PLANNING APPEAL STATEMENT

SITE: 77 ALDWICK ROAD, BOGNOR REGIS, WEST SUSSEX, PO21 2NW

PROJECT: PART CHANGE OF USE OF GROUND FLOOR & FORMATION OF A FIRST FLOOR REAR EXTENSION TO CREATE 2 NO SELF-CONTAINED STUDIO FLATS WITH ASSOCIATED REFUSE / RECYCLING & CYCLE STORE (RE-SUBMISSION FOLLOWING BR/63/18/PL)

LPA / REF: ARUN DISTRICT COUNCIL / BR/233/19/PL

1357/P03 D

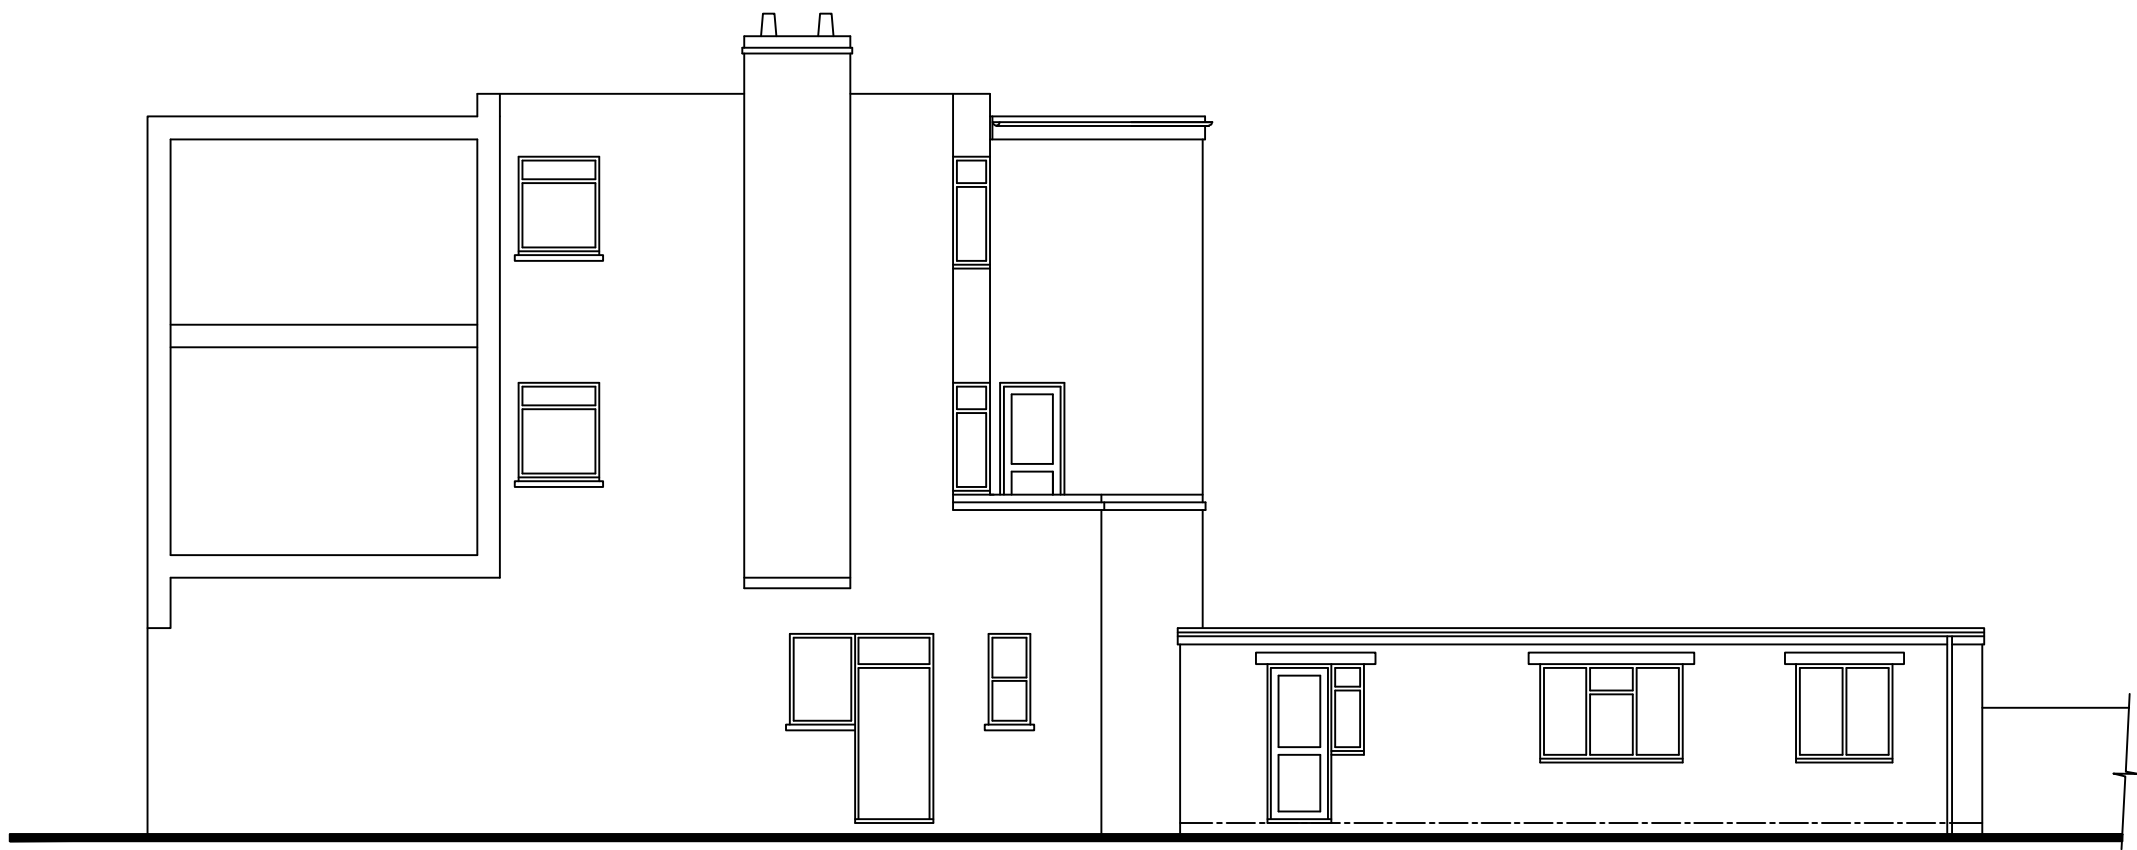
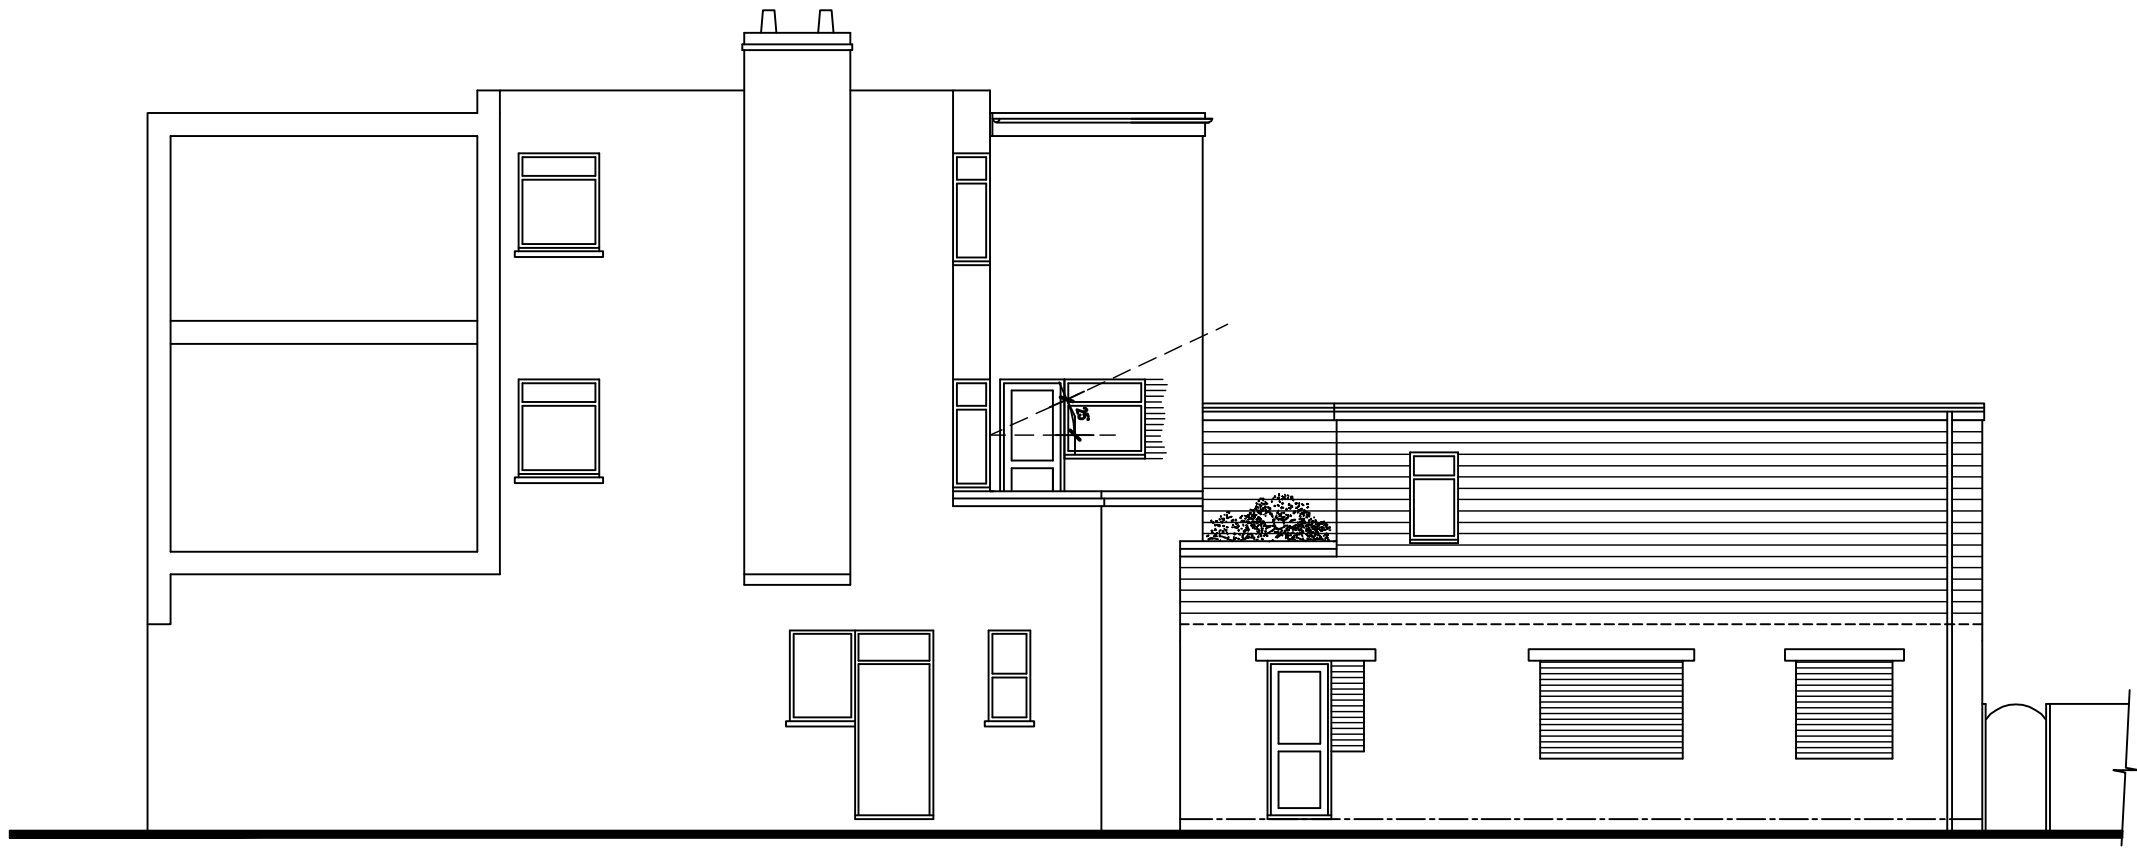
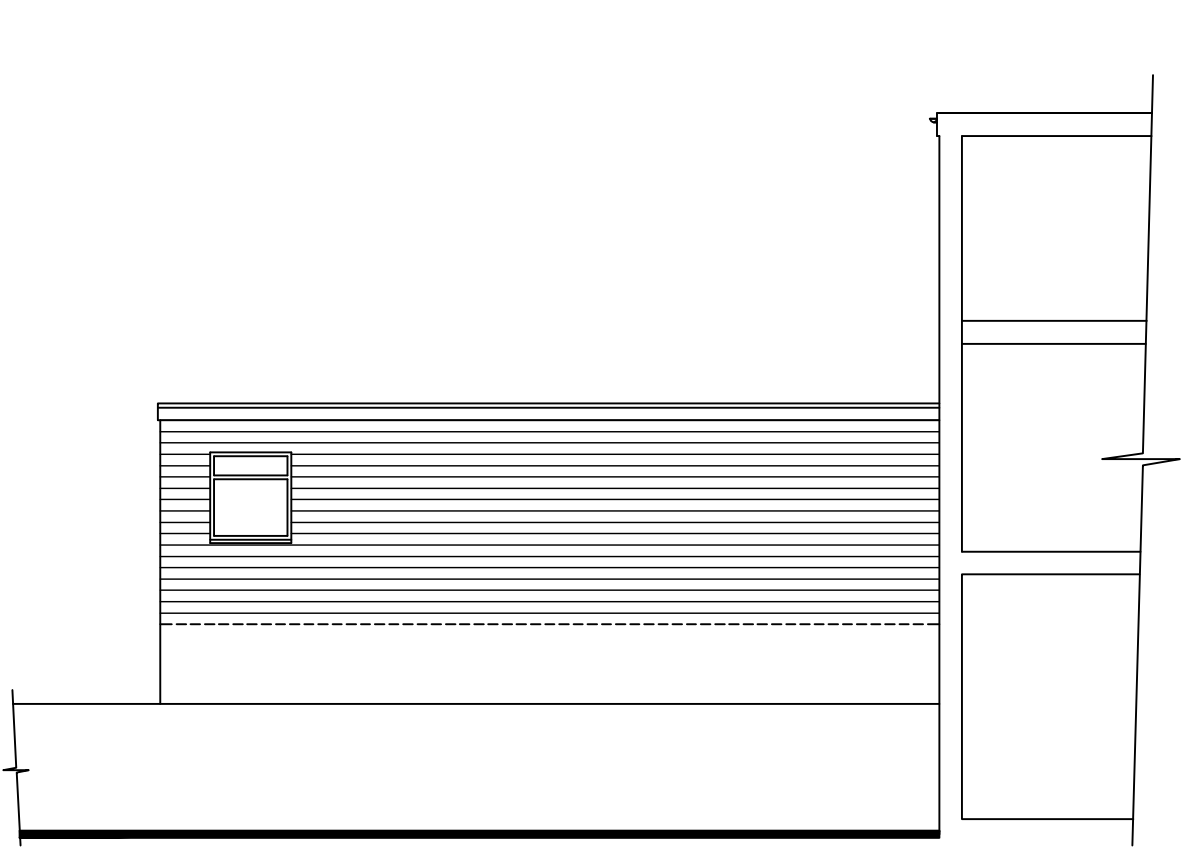
- 4.2.2 We have provided a full set of plans for the appeal scheme under separate cover, however for the purposes of clarity within this statement, we have provided figure 3 below. Figure 3 shows a dimensioned plan with the proposed extension shaded in purple and the windows of 75 and 79 Aldwick Road in blue. The plan also shows in green and circled the height of the proposed extension when taken from the datum point of 0.0 which has been set at the internal finished floor level of the relevant flats. It can be seen that the highest point of the proposed extension will sit 1.8m above the internal floor level of the flats at nos. 73 - 79. The latter can be seen on the section / elevation through the main building on drawing ref: 1357/P03 Rev C.

- 4.2.3 The matter for consideration is therefore whether a first floor extension in its intended location is going to have an overbearing impact and loss of outlook on the internal living conditions of 73, 75 and 79 Aldwick Road. The proposed extension is positioned over 3.0m to the nearest window of no.79 Aldwick Road, and is 2.3m from the nearest point of the rear facing window on no.75 Aldwick Road.

- 4.2.11 The distance between the proposed extension and the nearest point of the window of no.79 is 3.0m, and the nearest point of the window at no.75 is 2.3m from the proposed extension, albeit one would not be able to see the nearest point of the extension at 2.3m because this is on the same wall as the window. It is for this reason that an oblique view from the window of no.75 is only likely to see the proposed extension at a distance of 3m (taken on a diagonal line from a horizontal plane). Allowing for the set-back of a person standing within the room (i.e. taking into account the width of the window cill and wall), the actual separation distance between the person to be affected within the rooms of nos. 75 and 79 and the nearest point of the proposed development, is likely to be in the region of 3.3m.

- 4.2.12 To clarify therefore, the proposed development seeks to position a section of wall 1.8m high at a distance of no less than 3.3m from the alleged affected occupants of nos. 75 and 79. In addition, the proposed extension would be no more than 0.2m above the average person's eye height, meaning the difference is a height of 0.2m over a separation of no less than 3.3m. It is very difficult to understand let alone agree with the Local Planning Authority's position that this difference in height is so significant as to render the appeal scheme as being overbearing and resulting in a loss of outlook to the windows of nos. 75 and 79 Aldwick Road.
